**Hills Showground Station Precinct (SSD-9653)
Request for Additional Information**

I refer to the above Concept Application (SSD 9653) and the Department's previous correspondence requesting a response to submissions, dated 19 December 2019.

Date	29.10.2019	Drawn	DH	Checked	SA	Approved	LA
CAD File						Revision	
Drawing Number							
SK 08

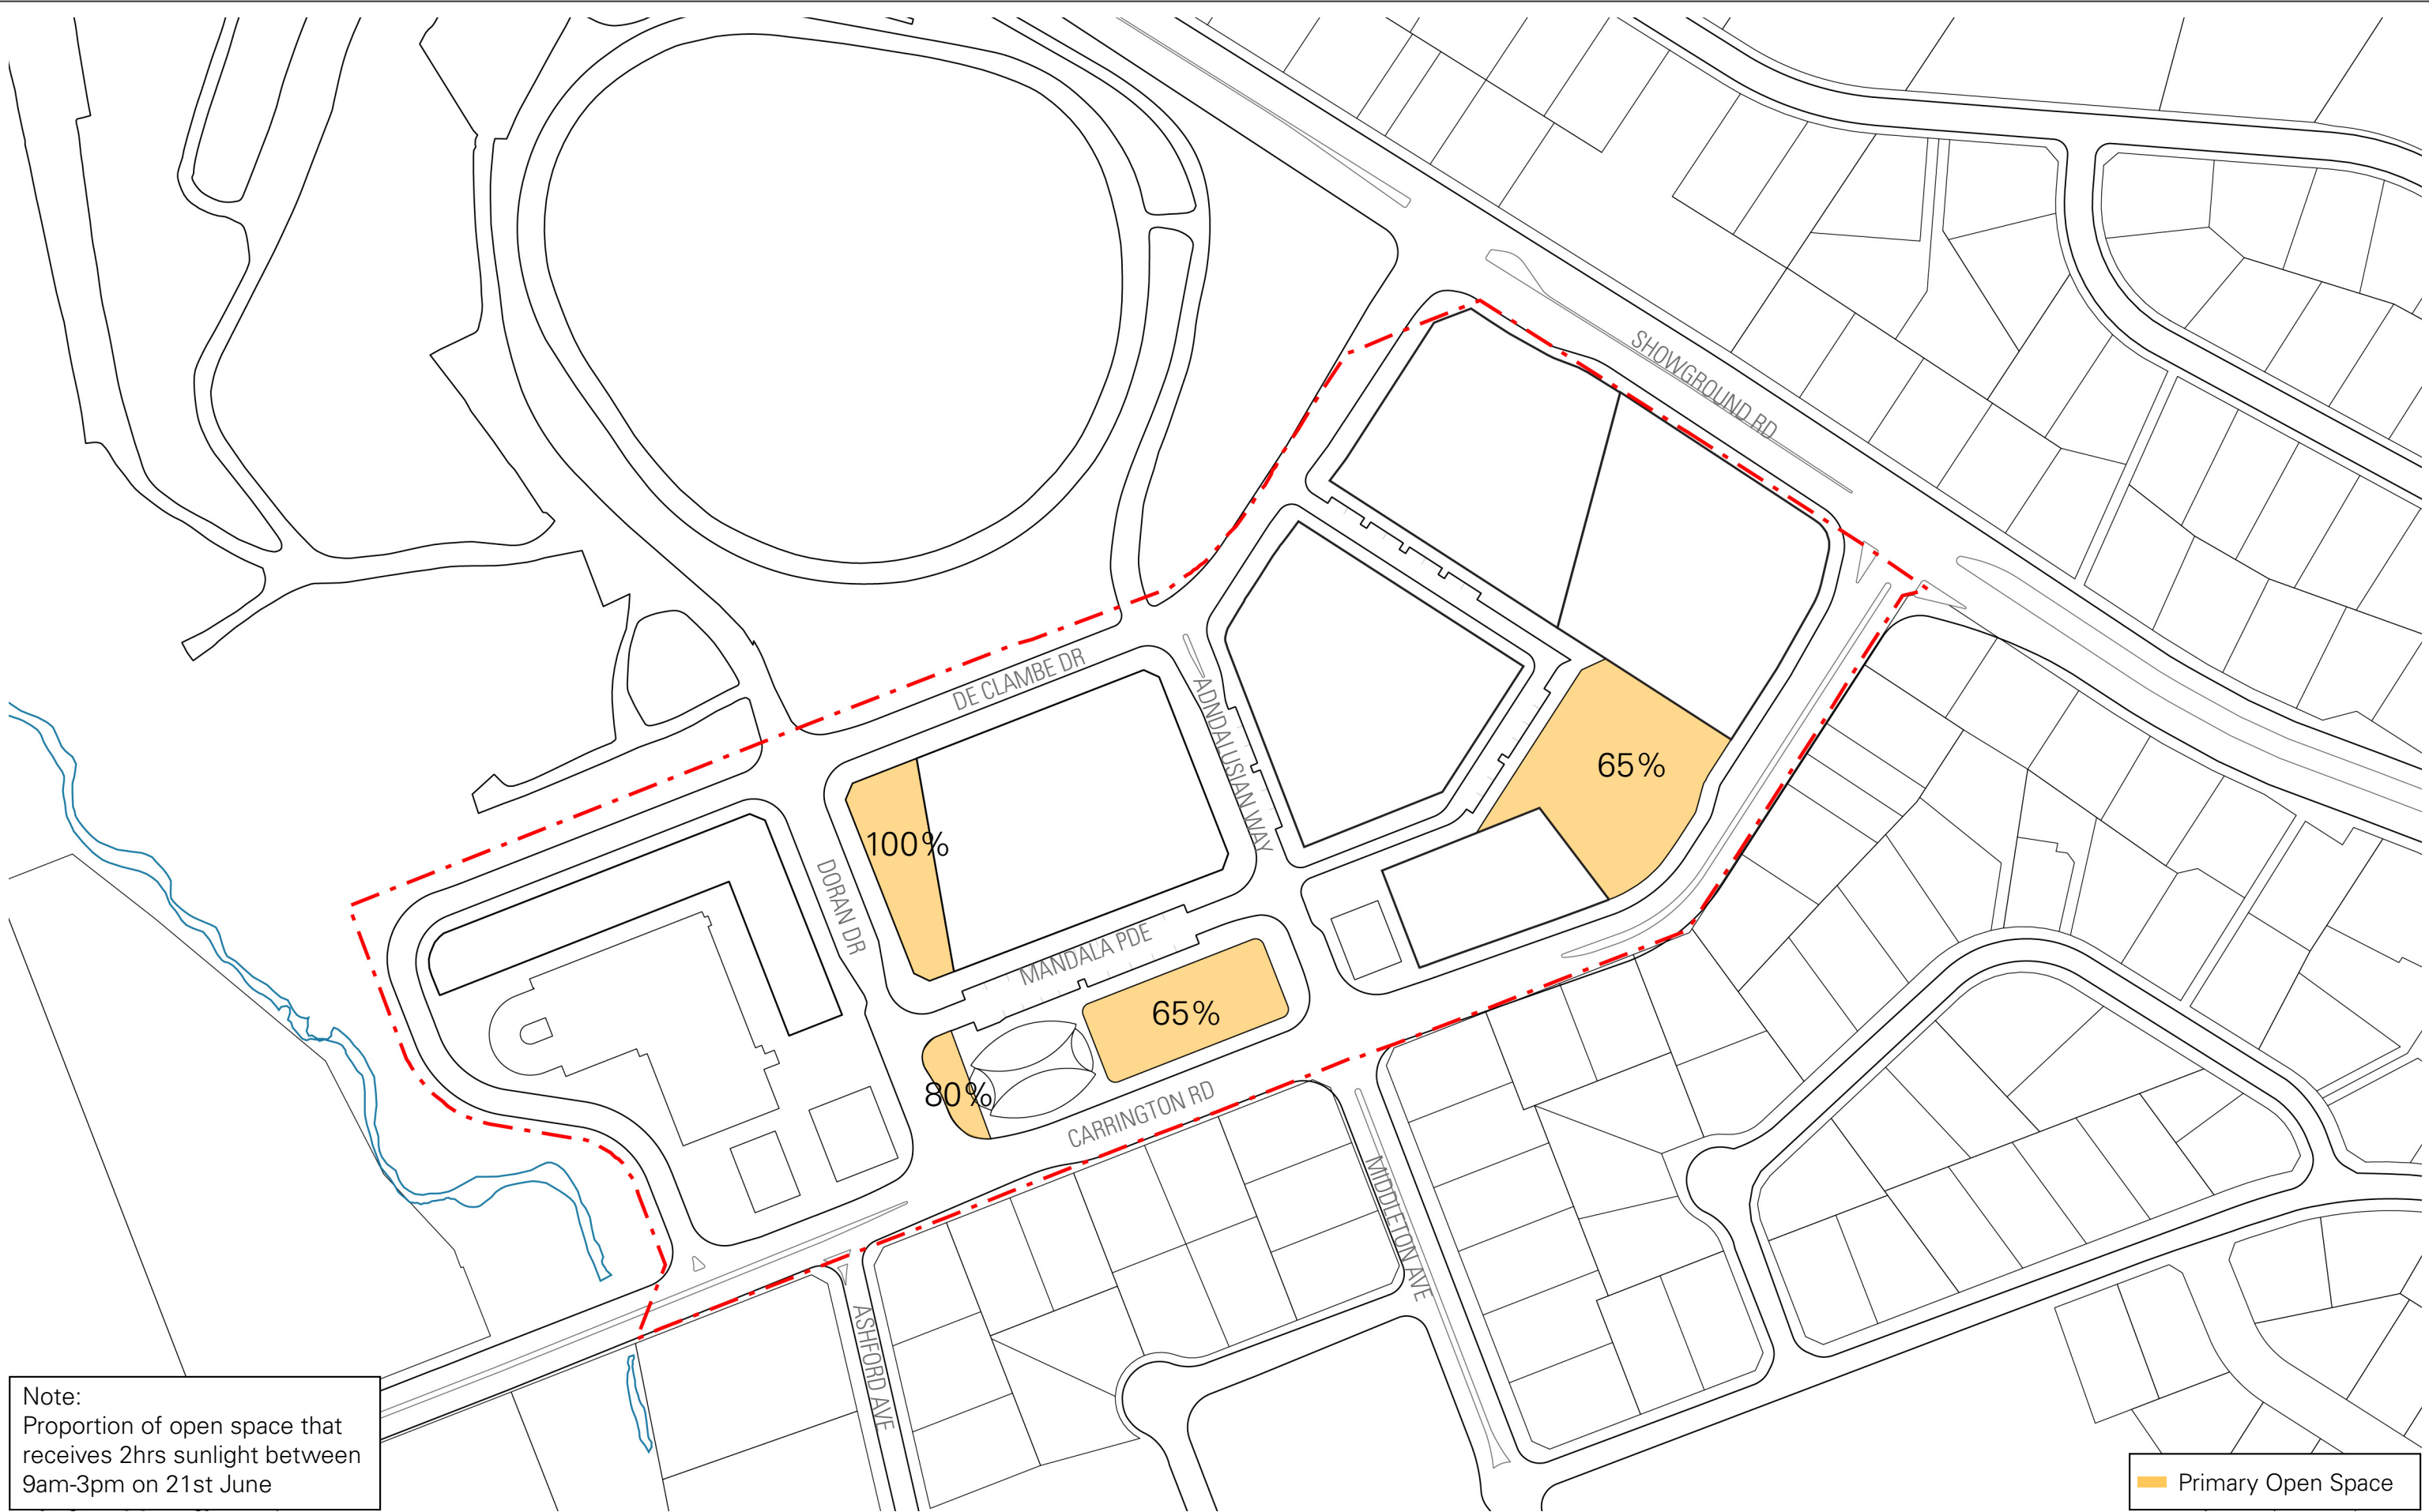
- iv. Submit additional shadow diagrams, at hourly intervals, demonstrating that the existing/ proposed public open spaces will receive adequate solar access.

Date	29.10.2019	Drawn	DH	Checked	SA	Approved	LA
CAD File						Revision	
Drawing Number							
SK 10

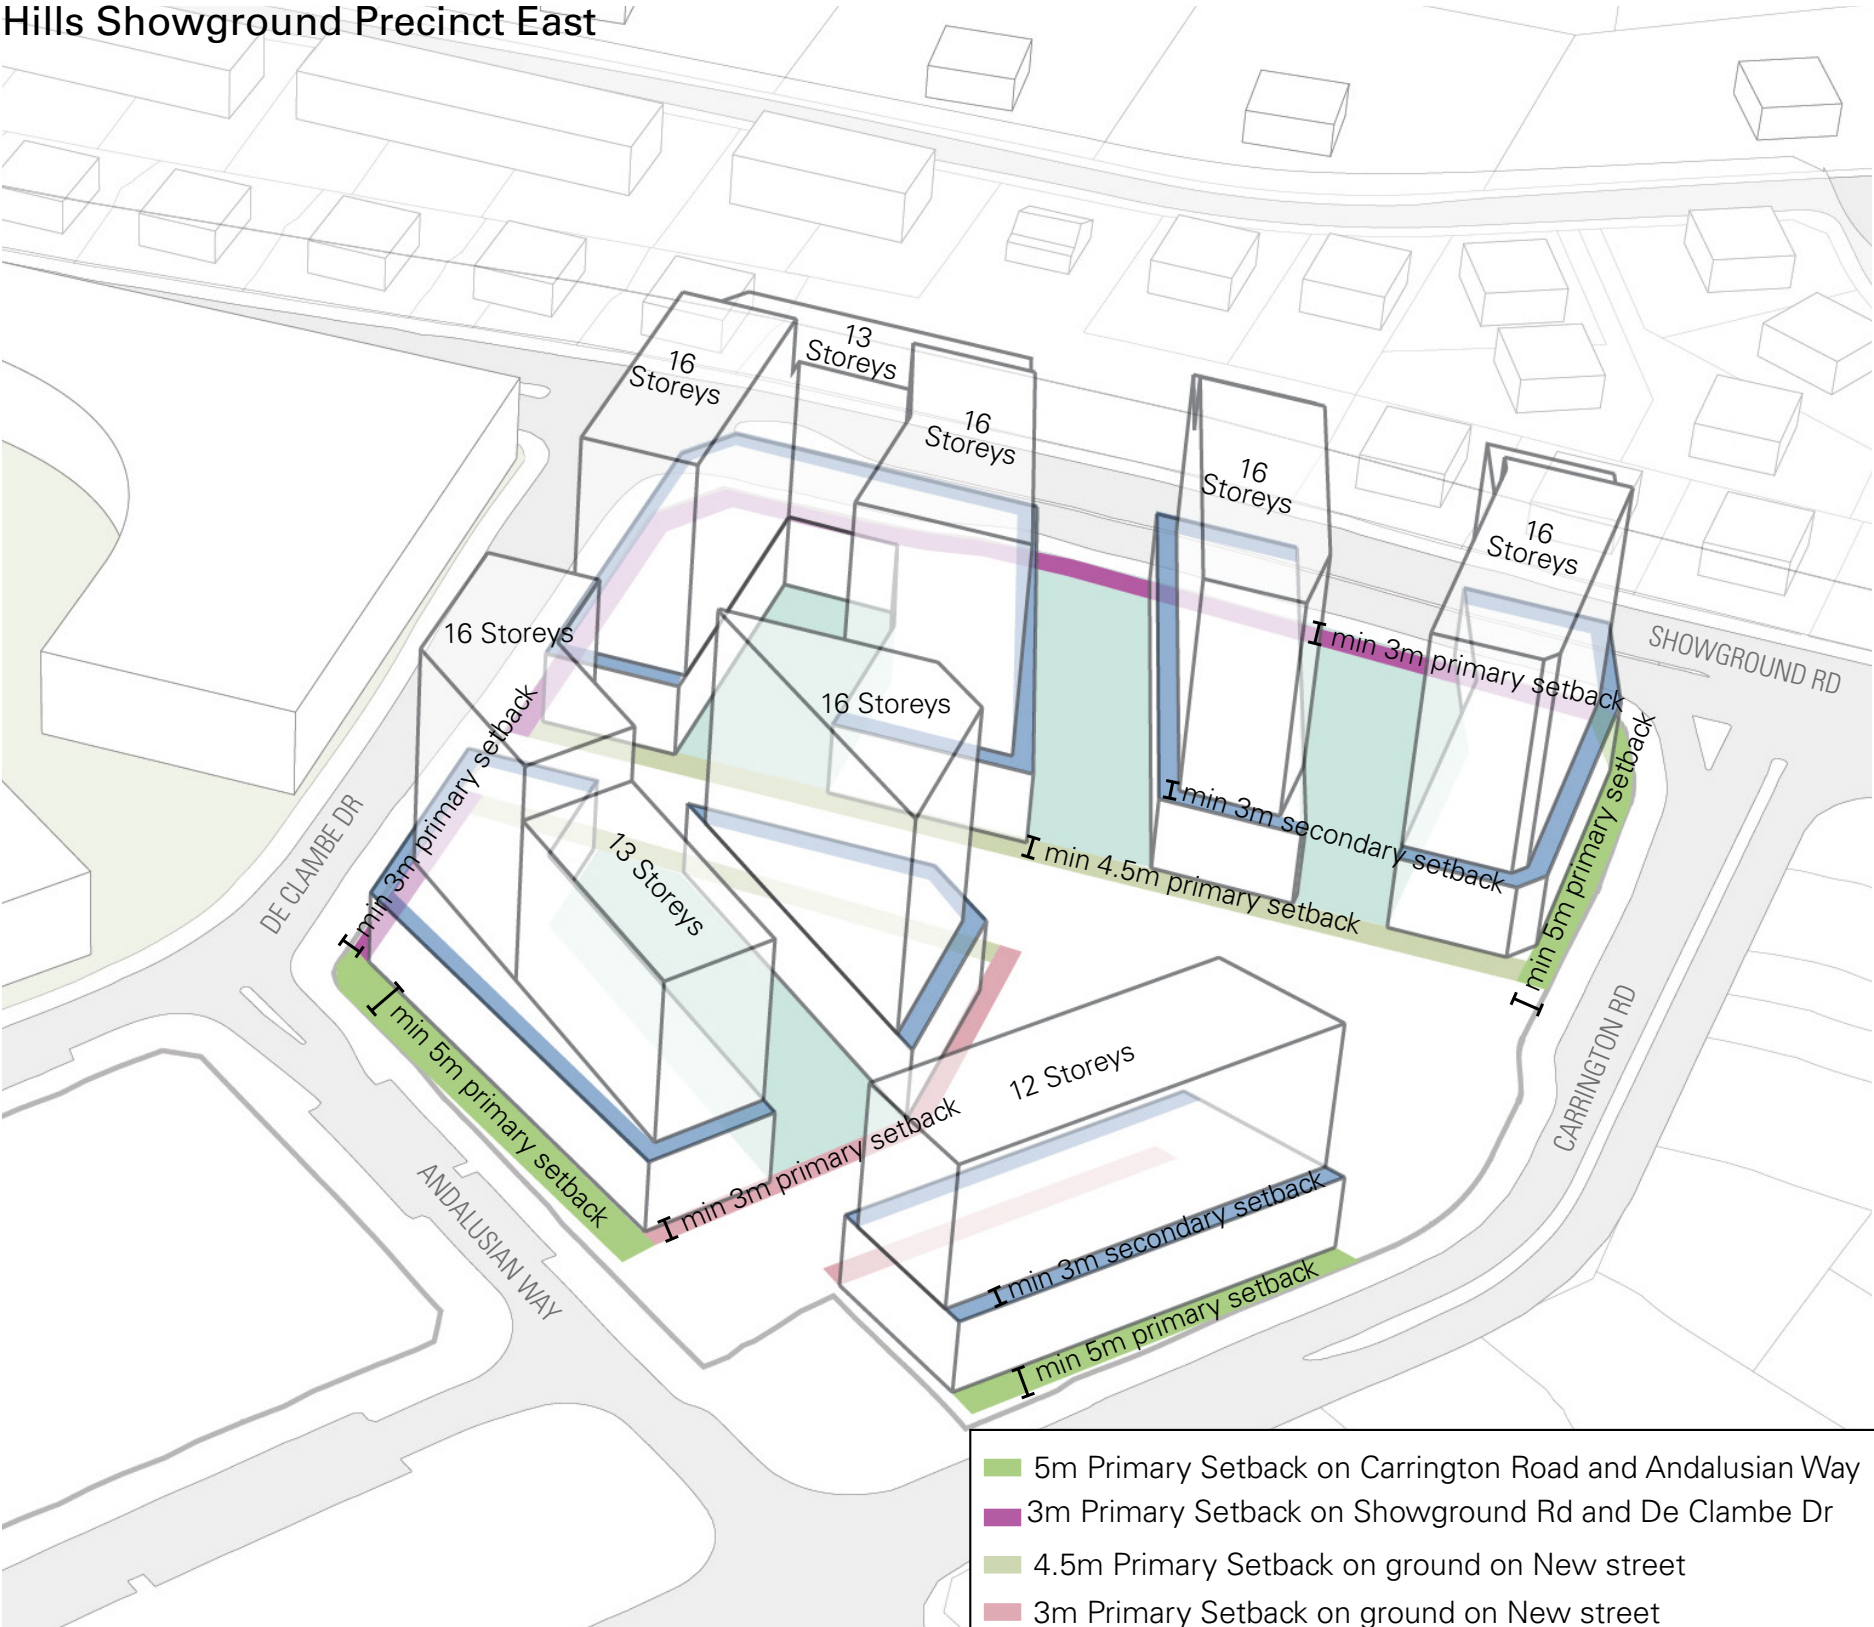
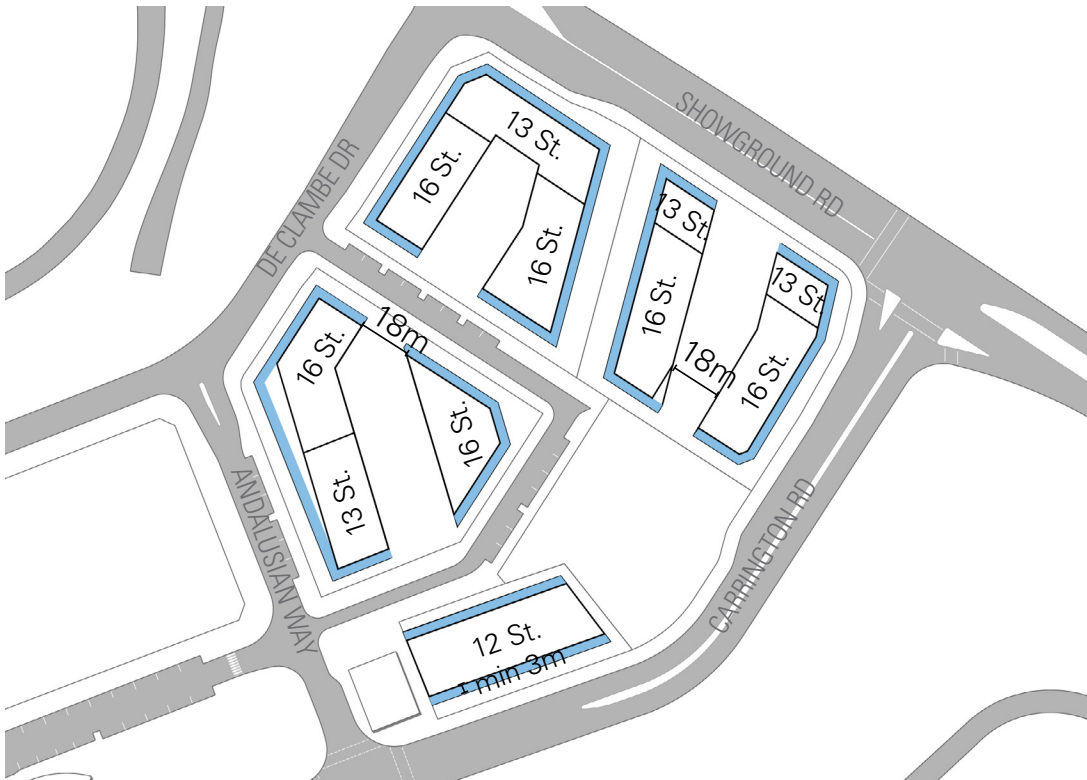
- i. Revise the proposed building envelopes to achieve improved amenity and compliance with the Apartment Design Guide (ADG). This may require a reduction or redistribution of the proposed building mass and density.
